REQUEST

Current Zoning: ML-2 (manufacturing and logistics, 2)
Proposed Zoning: TOD-NC(CD) (transit oriented development, neighborhood center, conditional)

Approximately 4.54 acres located in the southwest quadrant of the intersection of Wilkinson Boulevard and Remount Road, north of Parker Drive.

The petition proposes to allow all uses in the TOD-NC district on lots that are currently vacant. The conditions of the plan reserve right-of-way for the future LYNX Silver Line.

**RZ - 100**  
 FILE NO.:

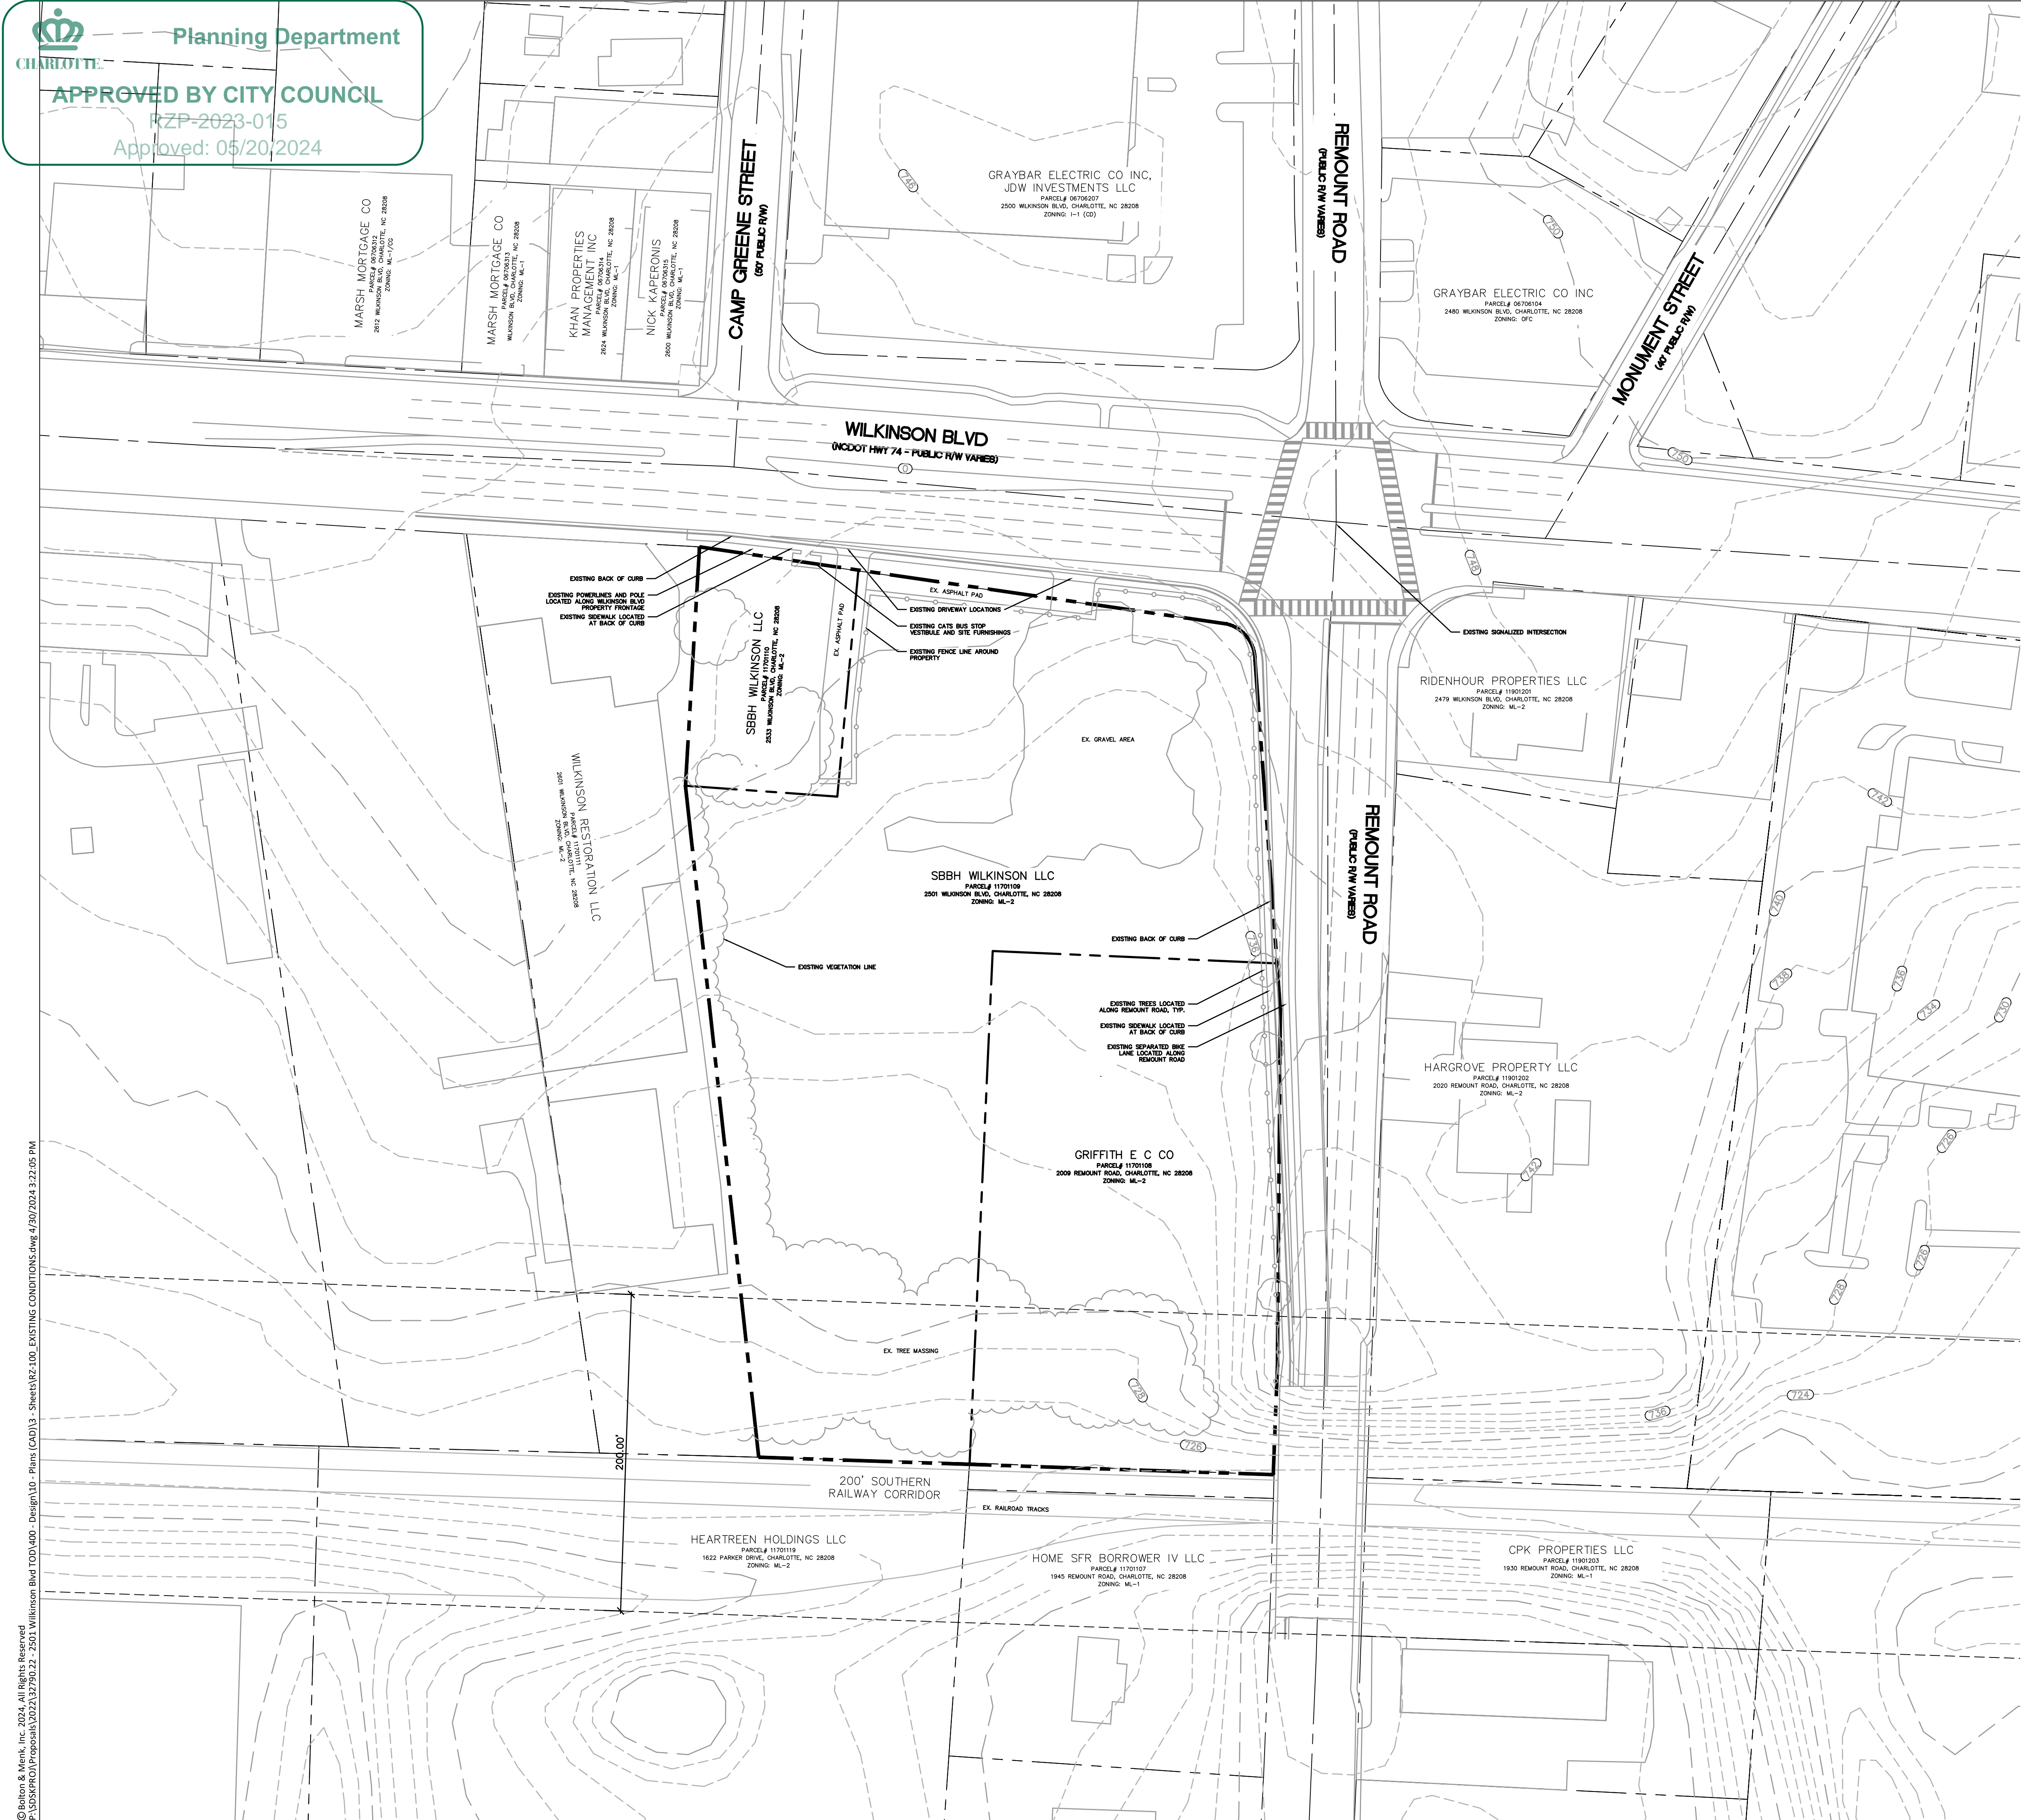
2. ~~Revise the site plan to dimension and label the right-of-way from the road centerline.~~ **Addressed**
3. ~~Modify the width of the reservation area from 85' to 130'.~~ **Addressed**

**DEVELOPMENT NOTES**

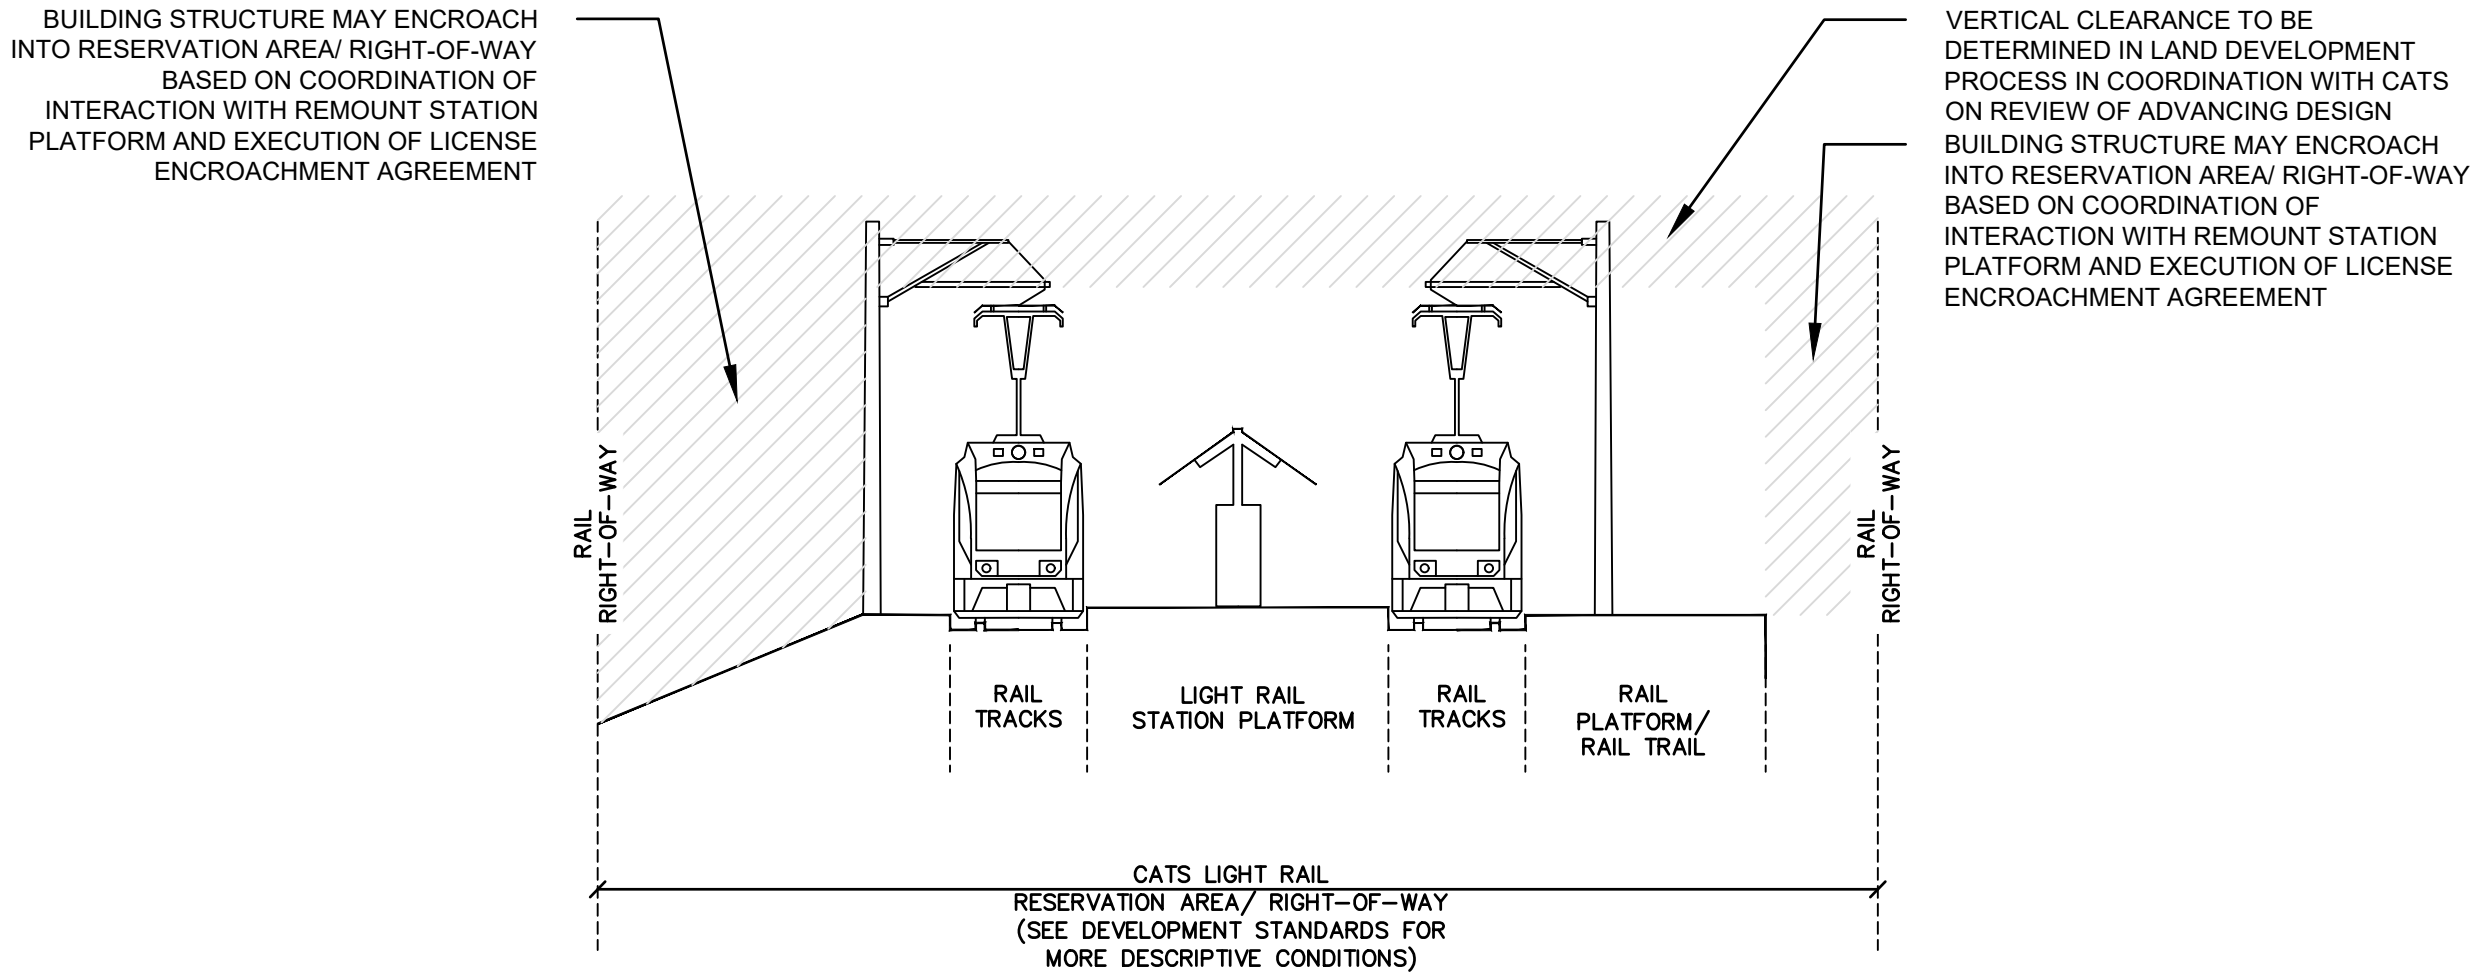
11. Revise the wording in (b.) in section 3 – Reservation of CATS Right of Way to read, "...public transit infrastructure in compliance..."
12. Revise the wording in (C.) in section 3 – Reservation of CATS Right of Way to read, "...the actual loading and dimensions may be modified..."
13. Revise the wording in (A.) in section 3 – Reservation of CATS Right of Way to read, "...to be incorporated into the building provided that the desirable clearance between..."
